Project Title: TLC Plumbing Co.

Re: **TLC Plumbing Office, Grading and Drainage Plan**
Engineer's Stamp dated 10-08-04 (G15-D62)

**Re: TLC Plumbing Office, 5030 Edith Blvd NE, Traffic Circulation Layout
Architect's Stamp undated (G15-D62)**

Re: TLC Plumbing Office, Traffic Circulation Layout (G15-D62)

SITE PLAN & TRAFFIC FLOW DIAGRAM

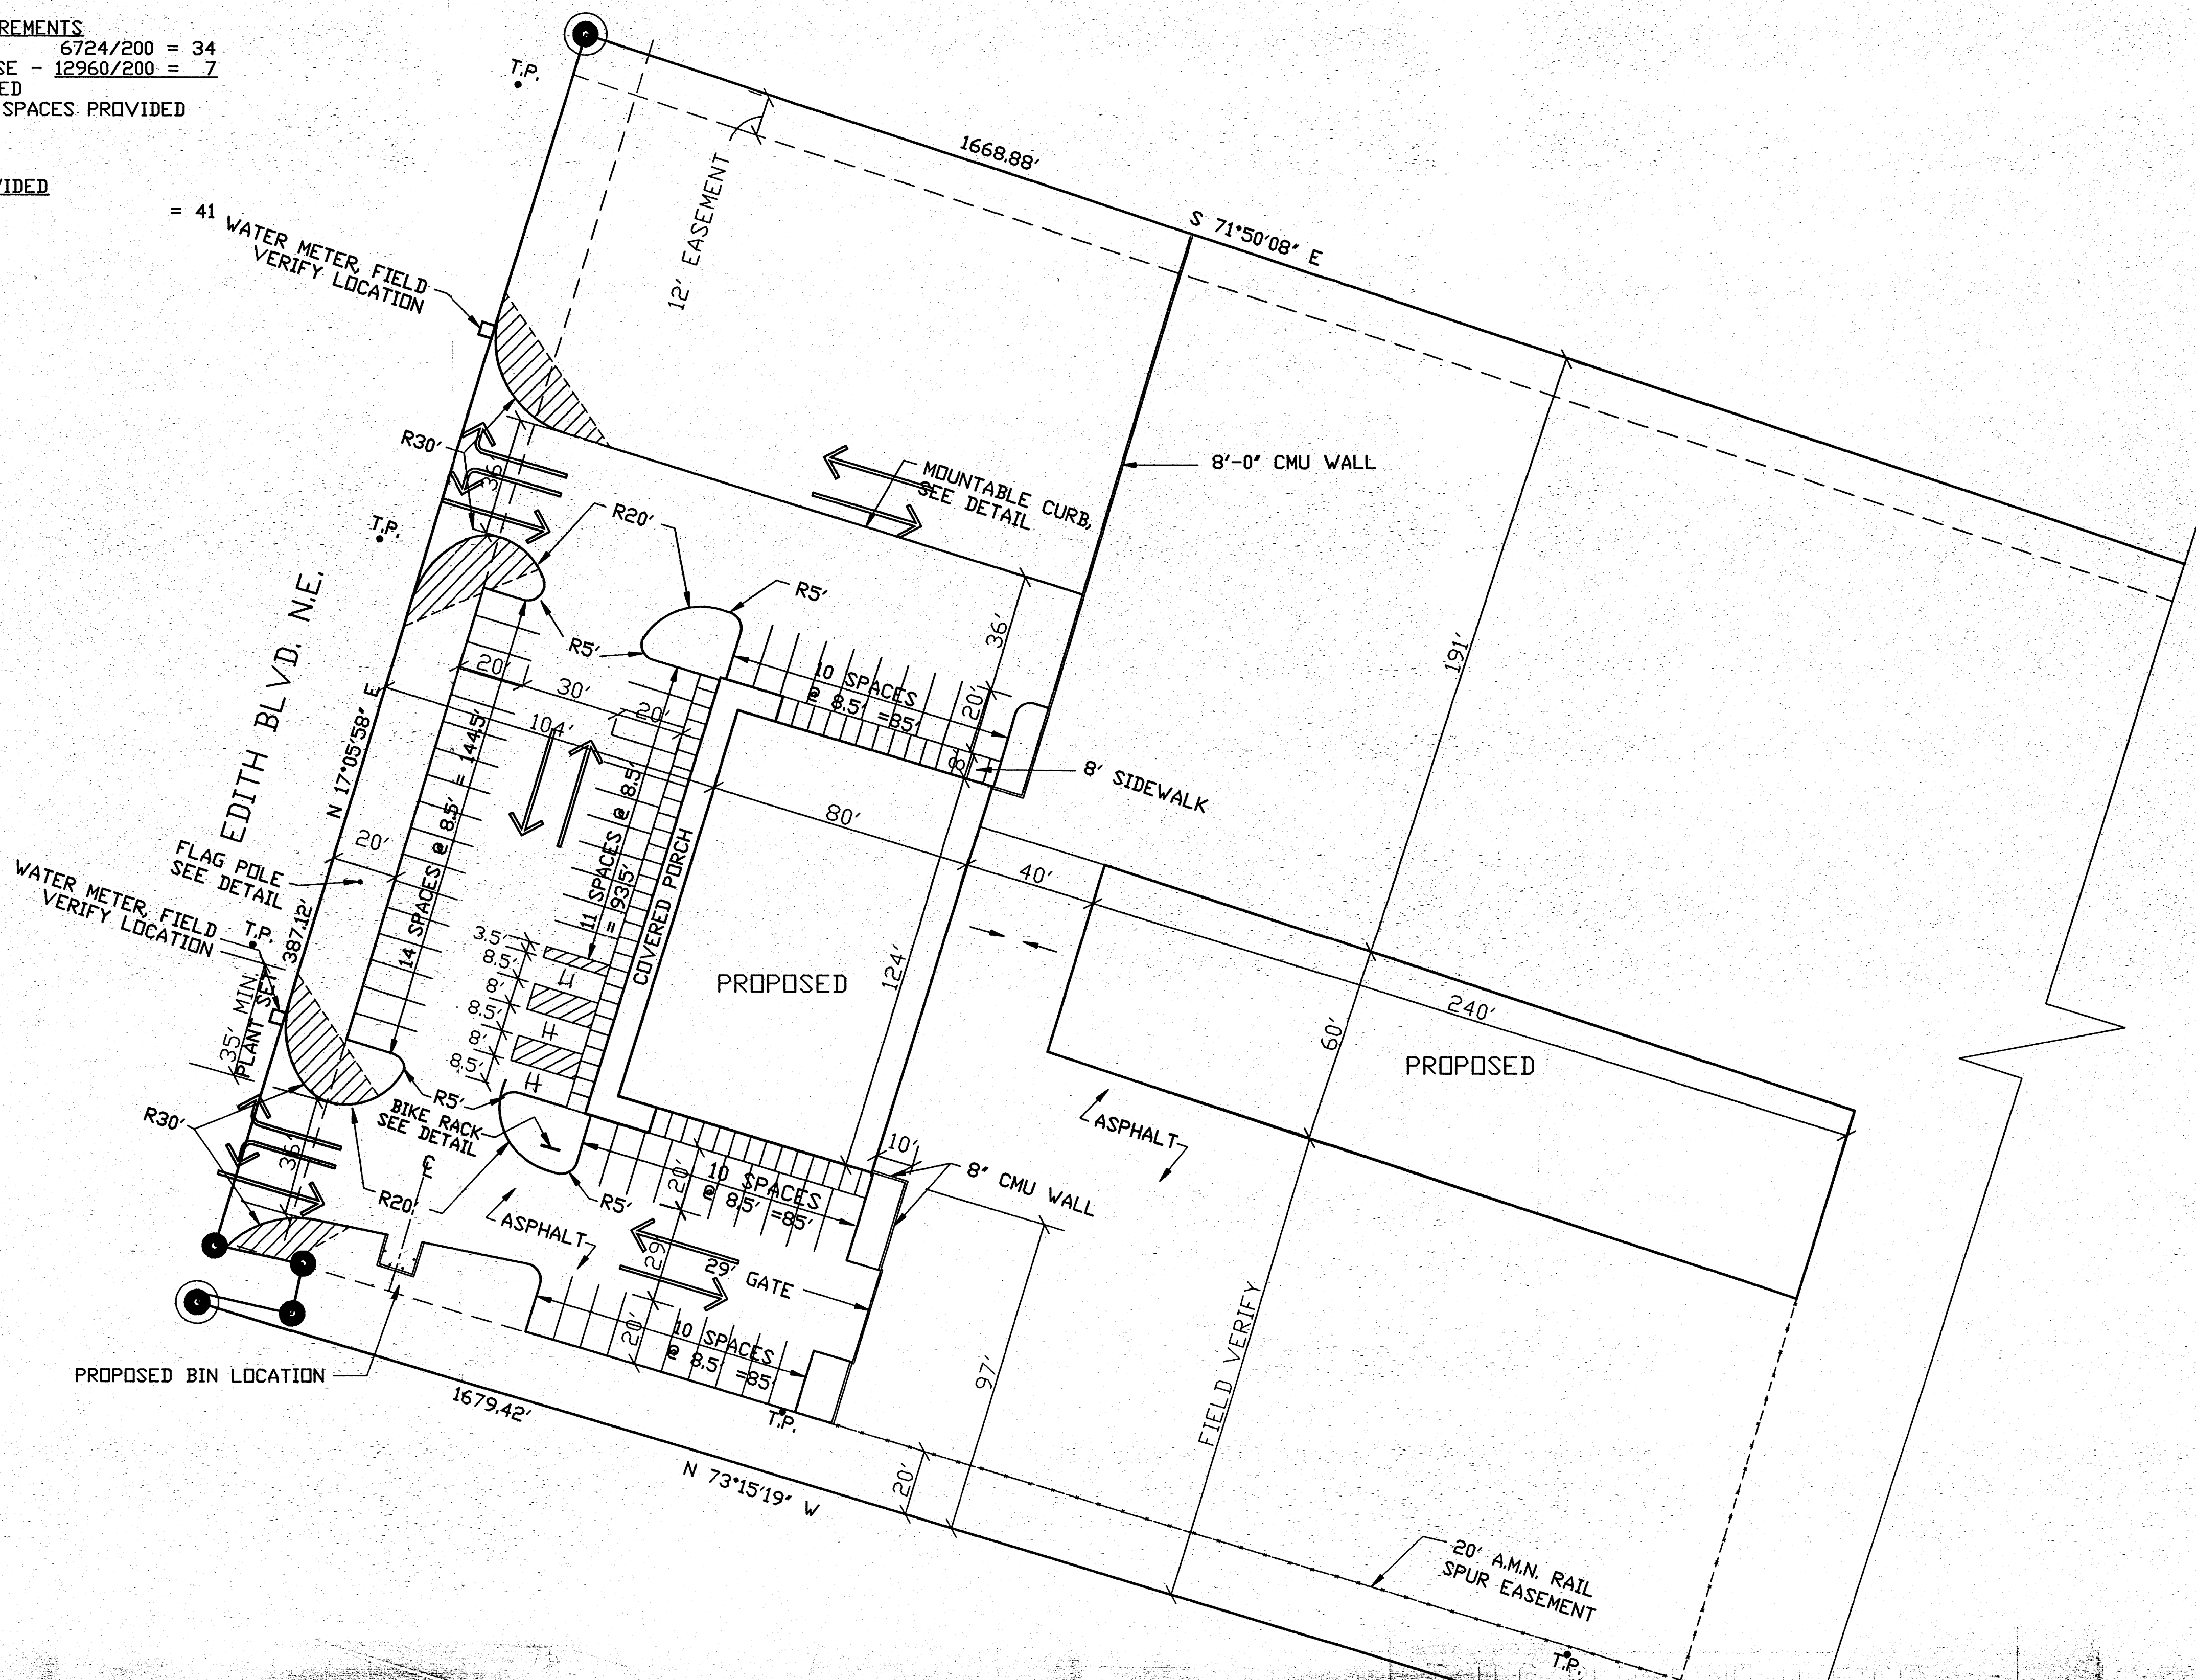
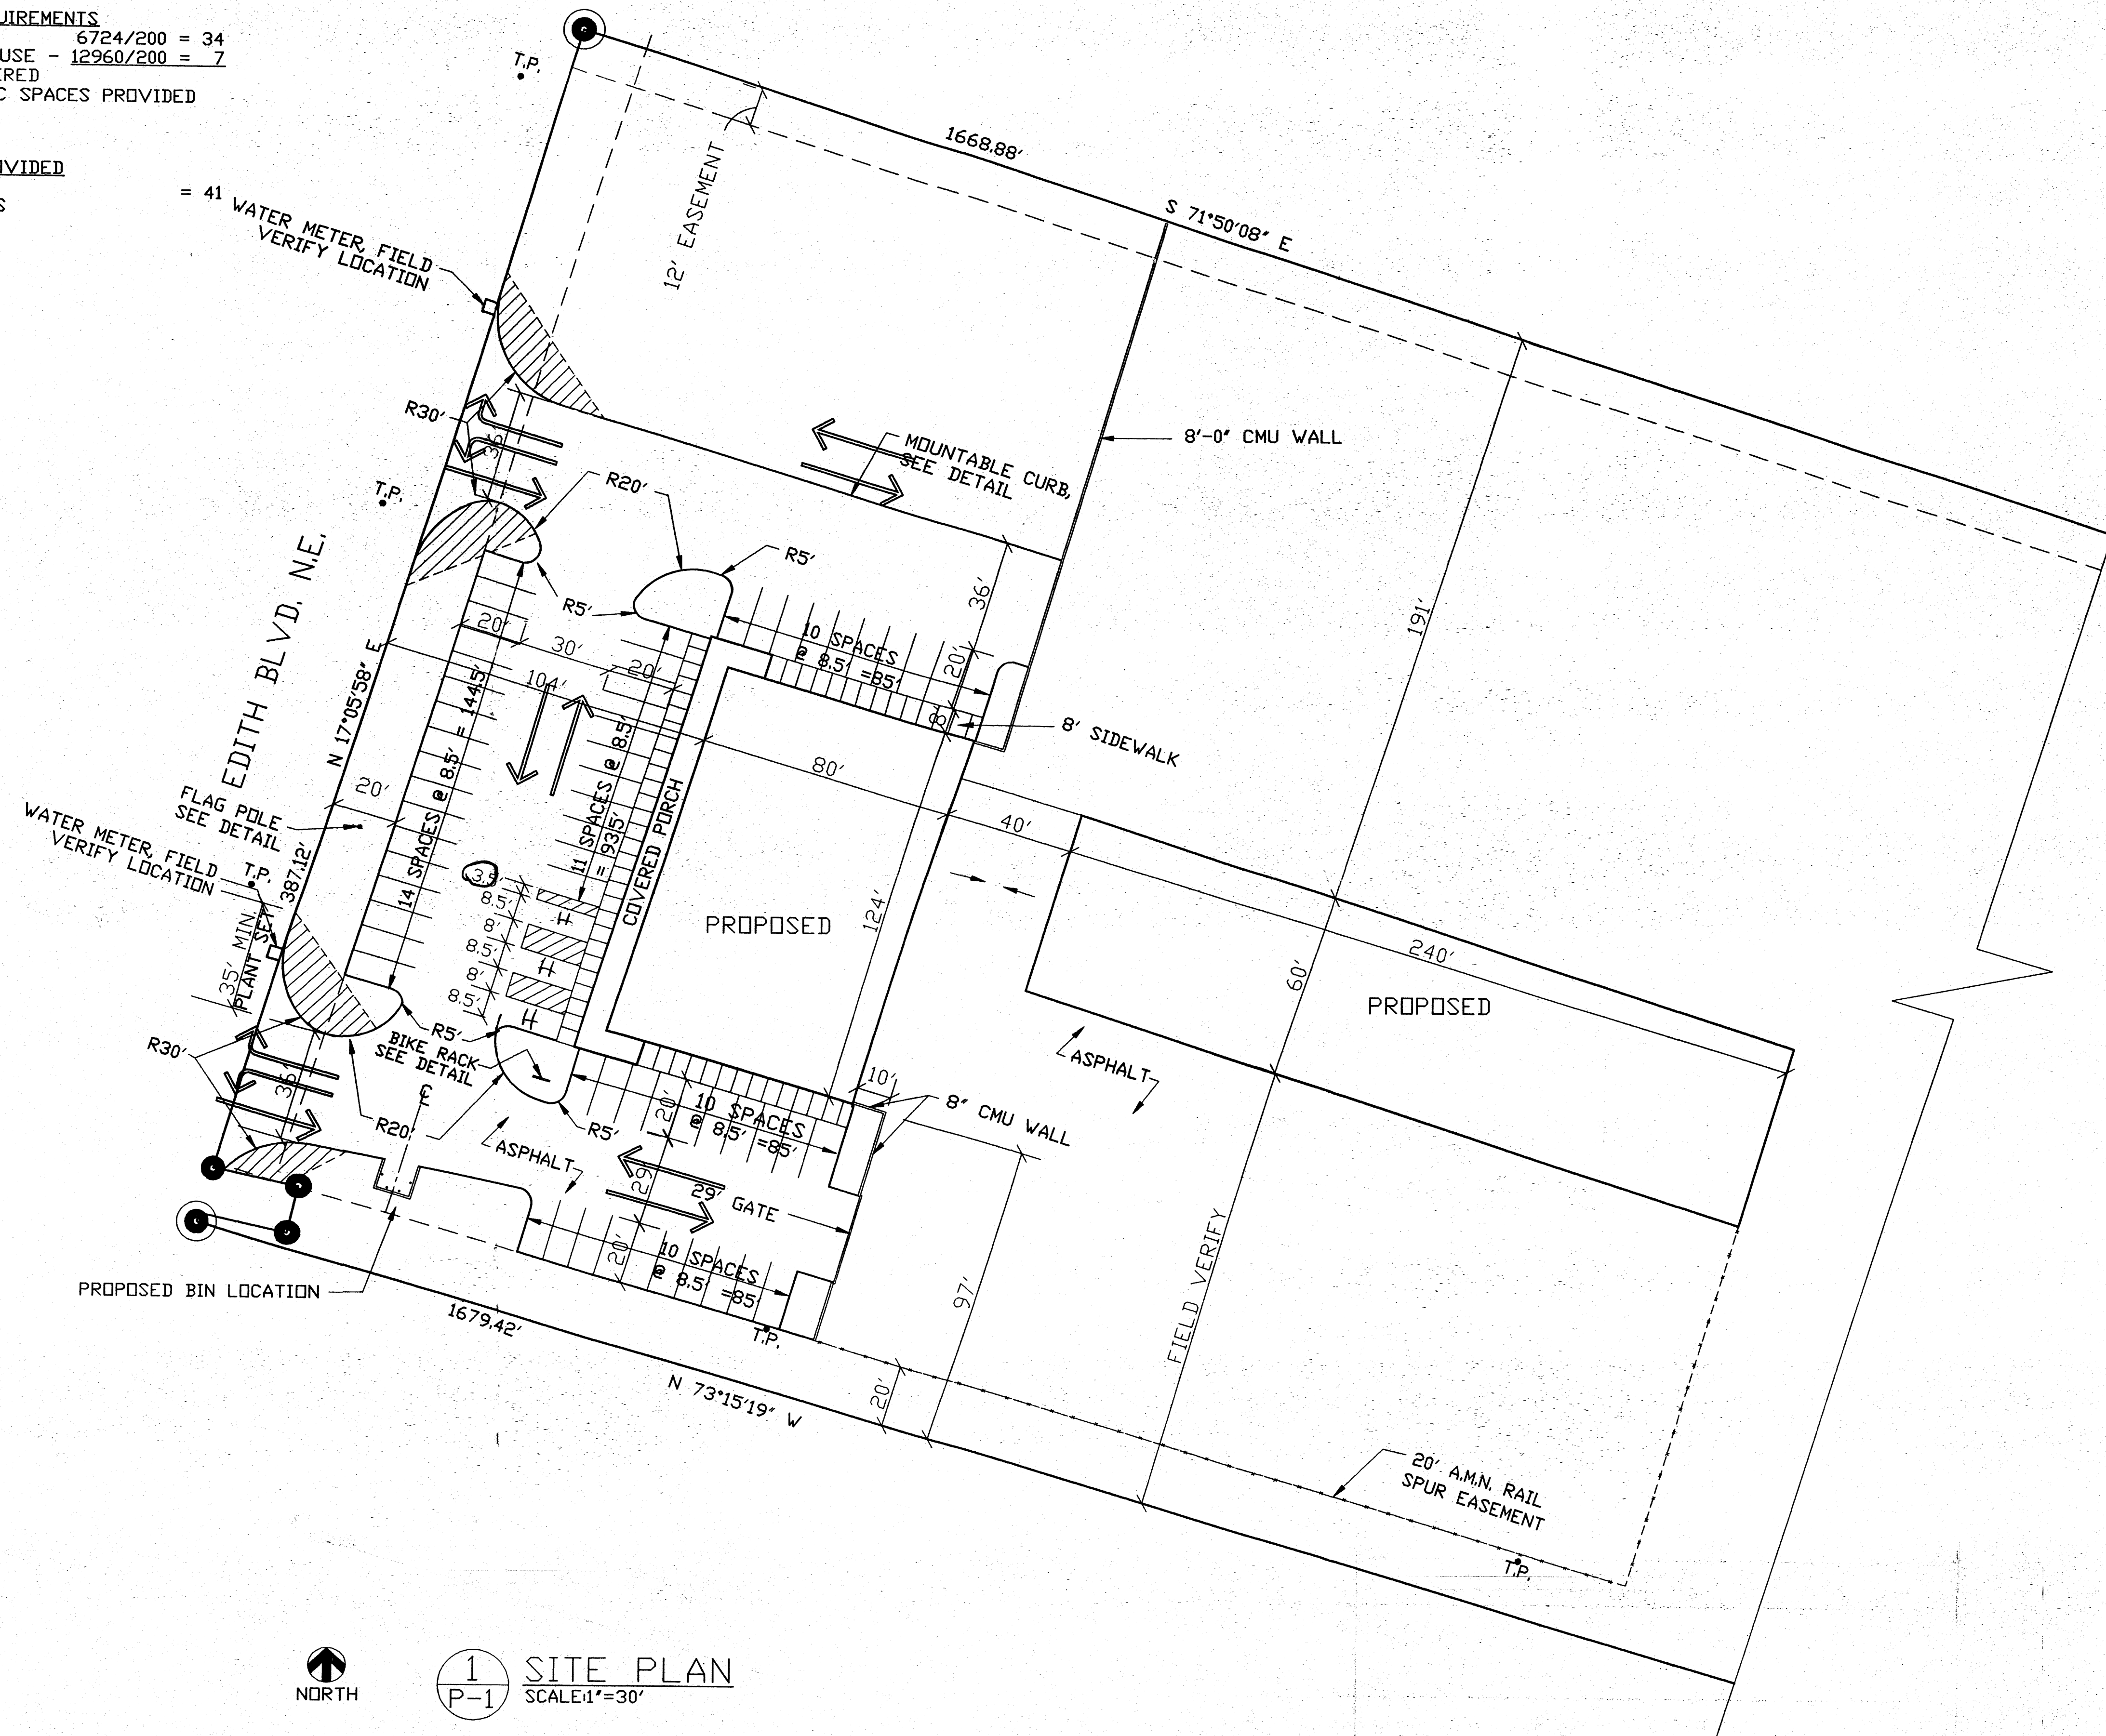
~~1.~~ The handicapped spaces must be a minimum of 8.5 feet in width with an 8-foot wide van access aisle.

3. The traffic circulation layout must be stamped, signed, and dated by an engineer or architect licensed in the state of New Mexico.

~~4.~~ List the number of parking spaces required by the zoning code as well as the proposed number of parking spaces.

~~5.~~ Please list the length for all parking spaces.

~~6.~~ Define width of the existing sidewalk.

~~7.~~ For passenger vehicles, the minimum end island radius is 15 feet.

8. A five-foot paved keyway is required for deadend parking aisles. *Call out keyway*
~~9.~~ If the site has left turn access, the drivepad has a 36-foot minimum width. If not, the drivepad has a 30-foot minimum width.

Need 8' aisle for HC spaces

5' key way
paved
